Re : Land at Stakers Farm, Yapton – Y/71/20/RES

Further to the e-mail of the 15th September 2020 containing drainage queries we would like to provide additional information to address these.

ROAD TYPE 5 & 5A CONSTRUCTION DRIVEWAY
PERMEABLE BLOCK PAVING

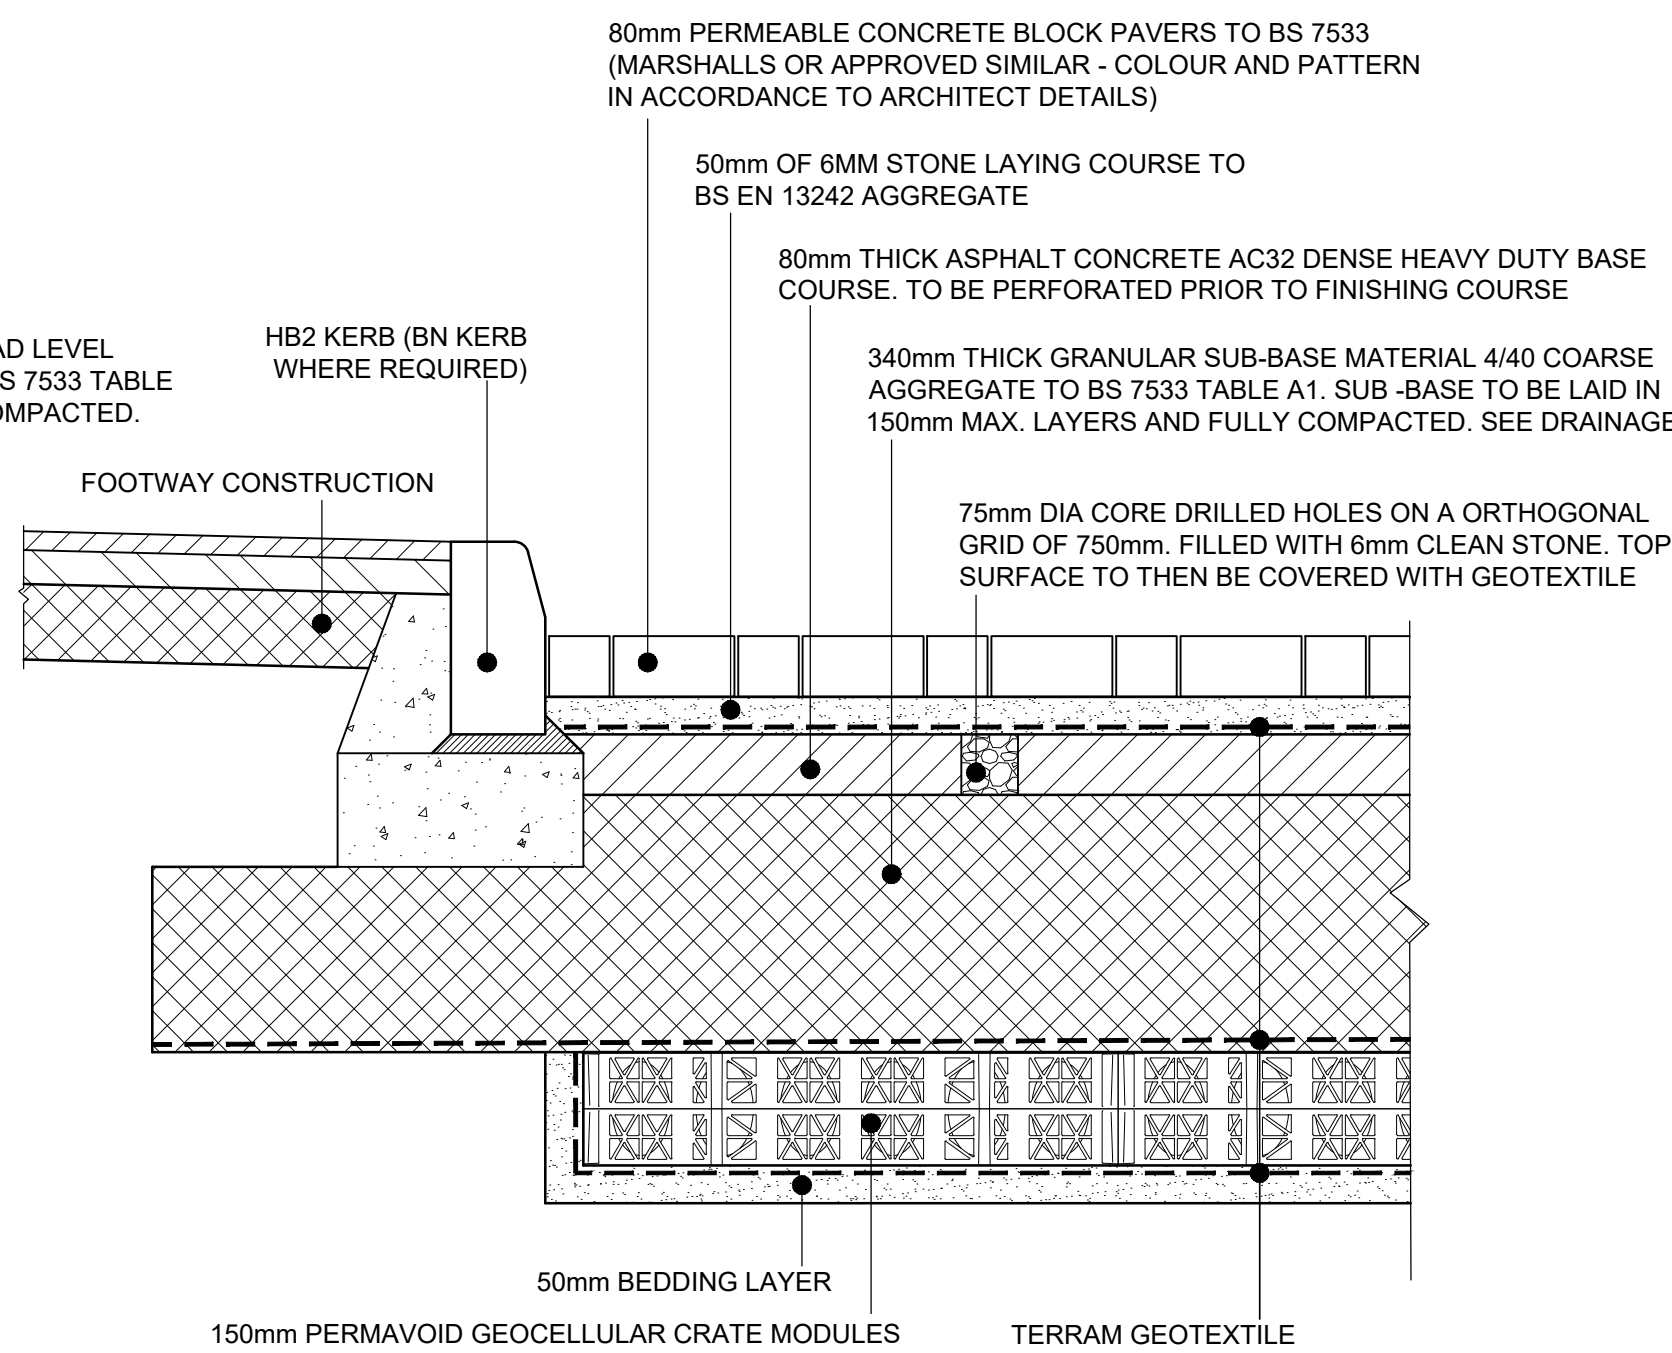
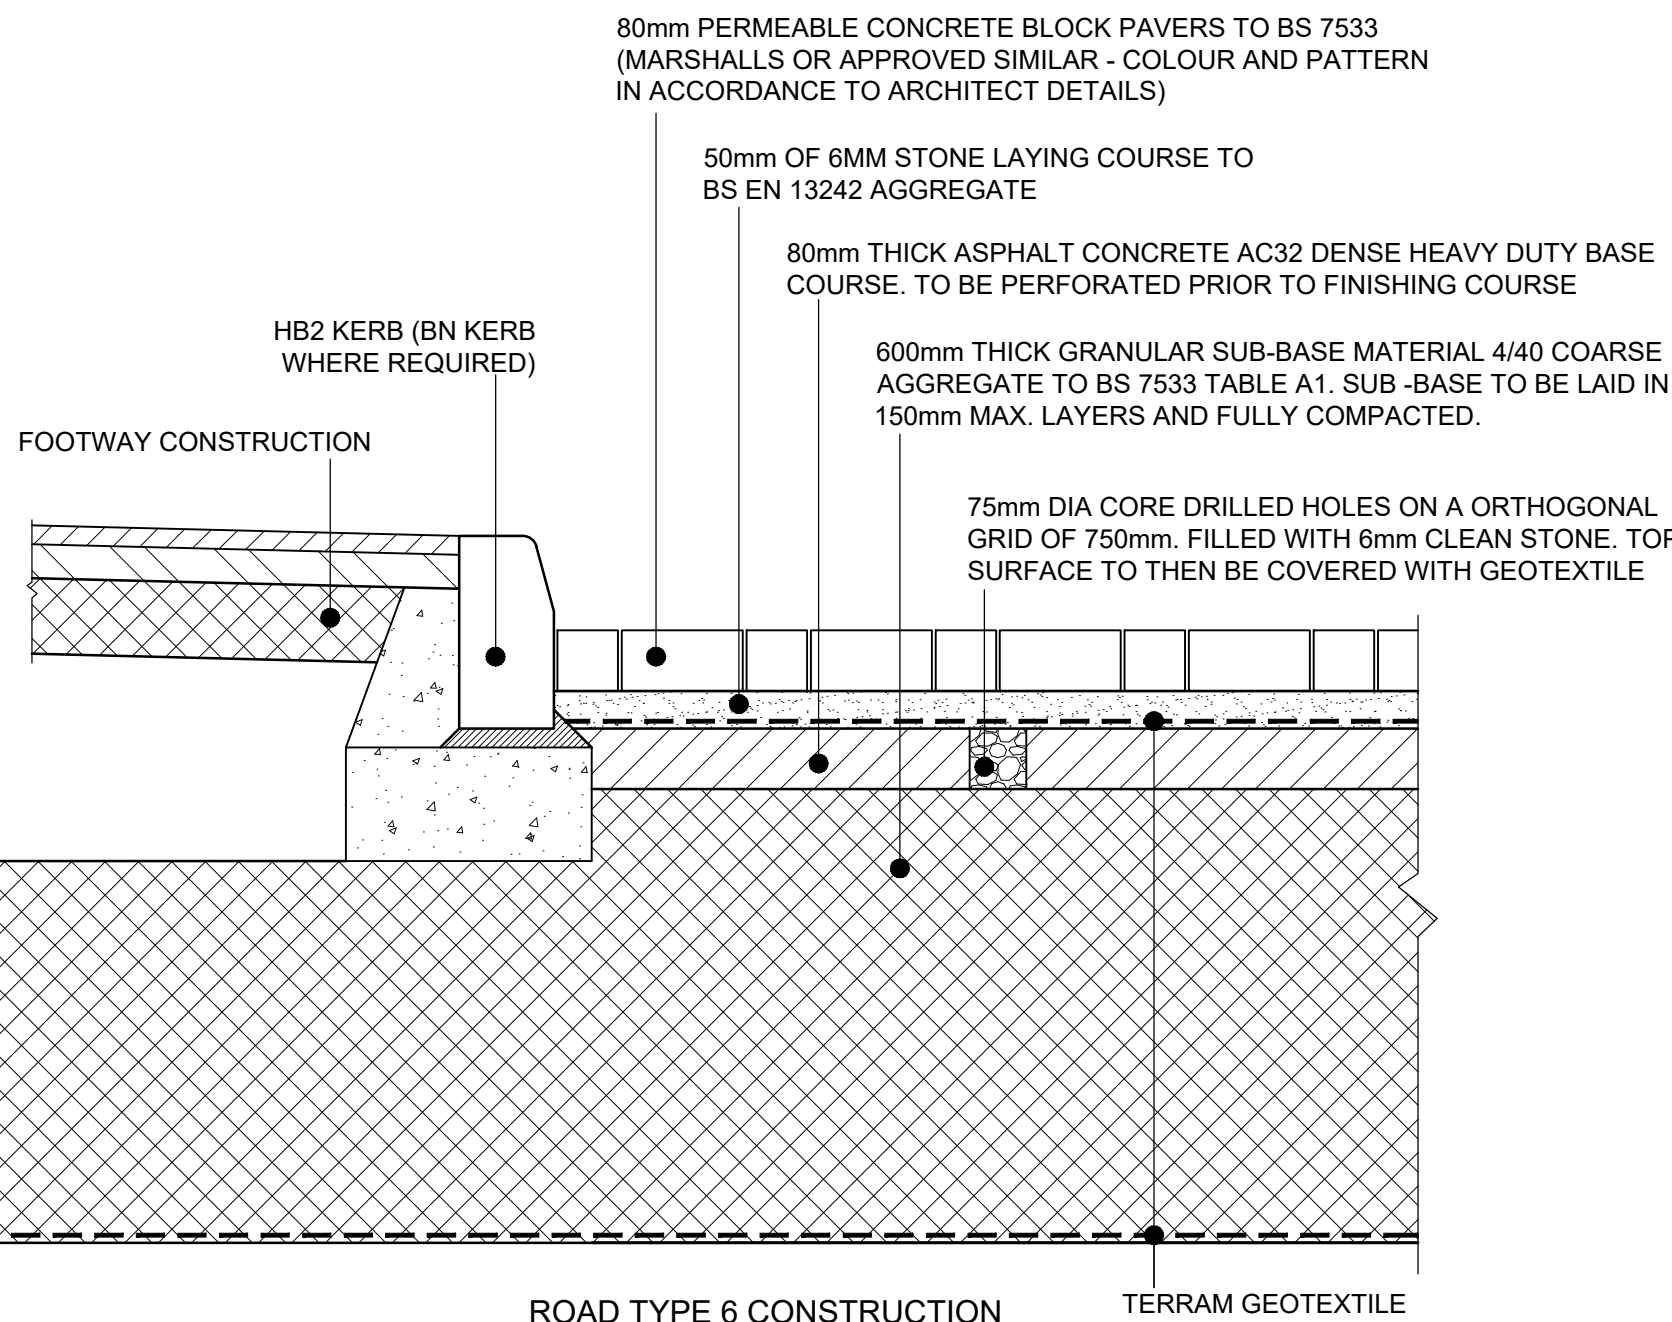
3. *"Please provide construction detail drawings of pipe bed and surround"* – Please refer to drawing YAP-180-31A.
4. *"Please provide construction detail drawings that clearly correspond to each of the proposed permeable paving types"* - Please refer to drawing YAP-180-35.
